NSW GOVERNMENT  
**Department of Planning**

Our ref: MP 05\_ 043  
Your ref:  
File: S07/00416-1

**Request for amendments and additional information – Lot 104, Precinct C, 42 Walker Avenue, Rhodes MP05\_0043**

NORTH ELEVATION BUILDING 2

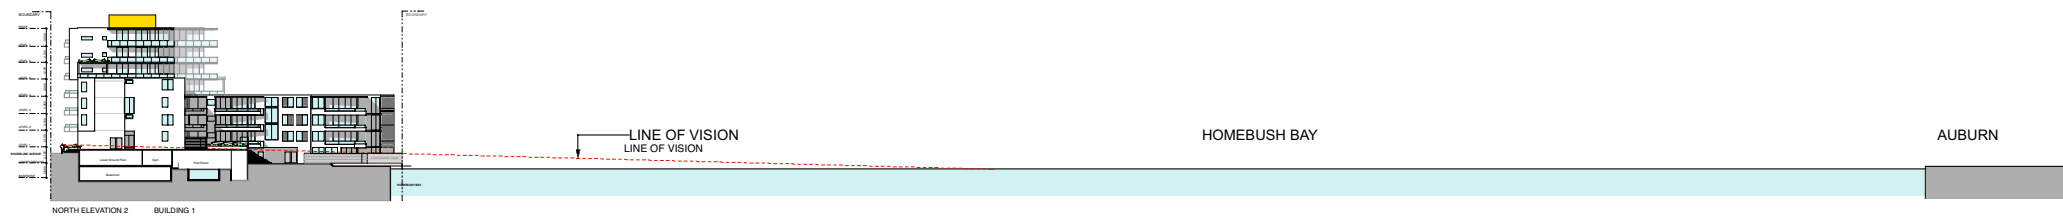
- Height - the proposal appears to breach the height control of the Concept Plan. A portion of Building 2 appears to be 6 stories in height and located within the 5 storey maximum height zone. A Section through this part of the building is required to be provided to accurately demonstrate the height of the building. All non-compliances with the Concept Plan are required to be addressed.

- The elevations and sections do not illustrate RLs for the ground levels or levels for the building;
- The size of the floorplate above 6 stories is required to be specified;
- A Materials and Finishes board;
- A BASIX Certificate and the corresponding BASIX Commitments illustrated on the plans; and
- Photomontages of all elevations (the submitted photomontage of the building as viewed from the water is insufficient to allow a comprehensive assessment).

SECTION 1 BUILDING 1

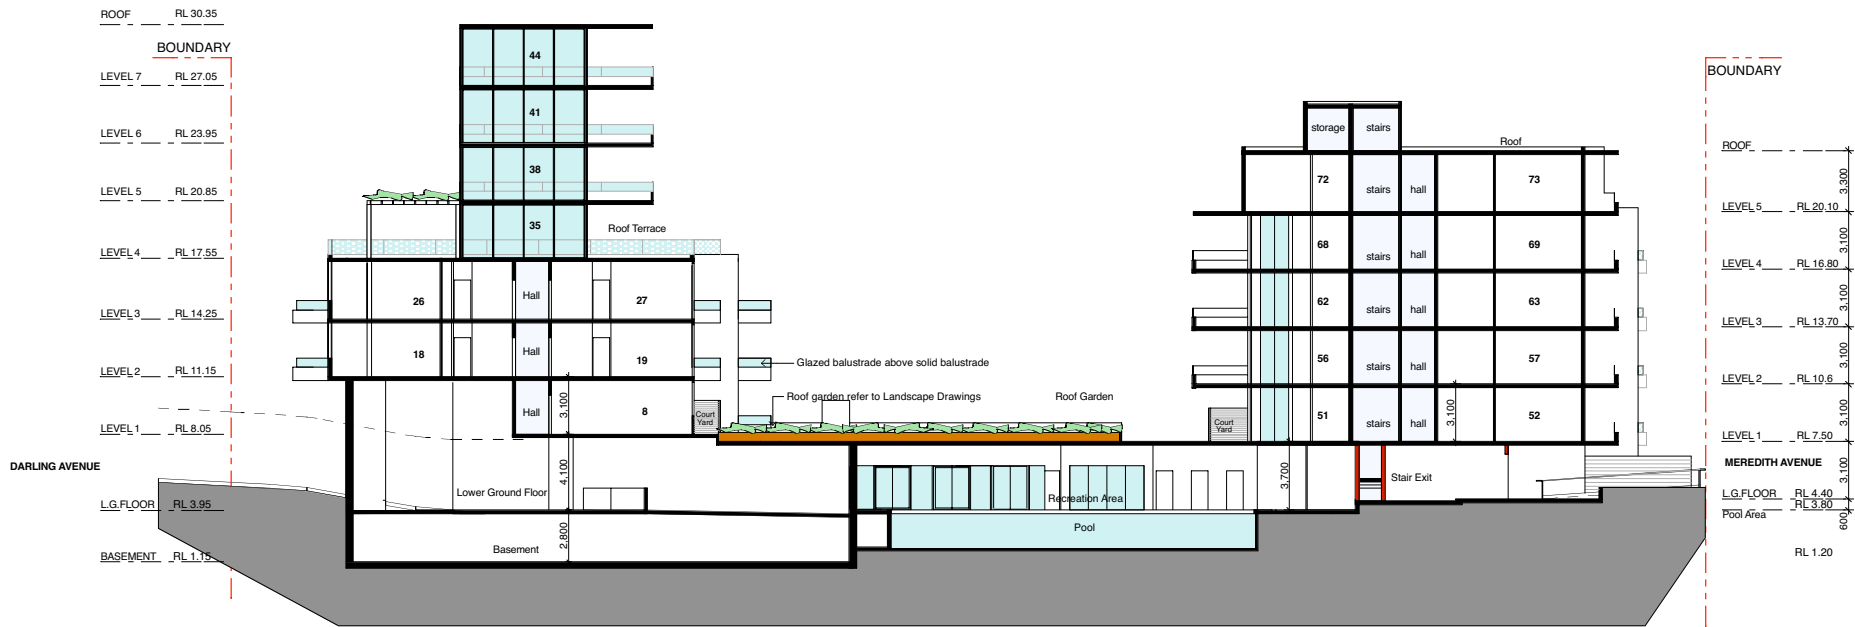
- The proposal appears to breach the height control of the Concept Plan. A portion of the Building 2 appears to be 6 stories in height and located within the 5 storey maximum height zone. A Section through this part of the building is required to be provided to accurately demonstrate the height of the building. All non-compliances with the Concept Plan are required to be addressed.
- Due to the need to clarify the heights of the building in relation to both the SREP No. 29 and Concept Plan requirements, the 4 and 6 storey zones in the Height Map accompanying SREP No. 29 and the height limits under the Concept Plan are required to be transposed onto the plans.
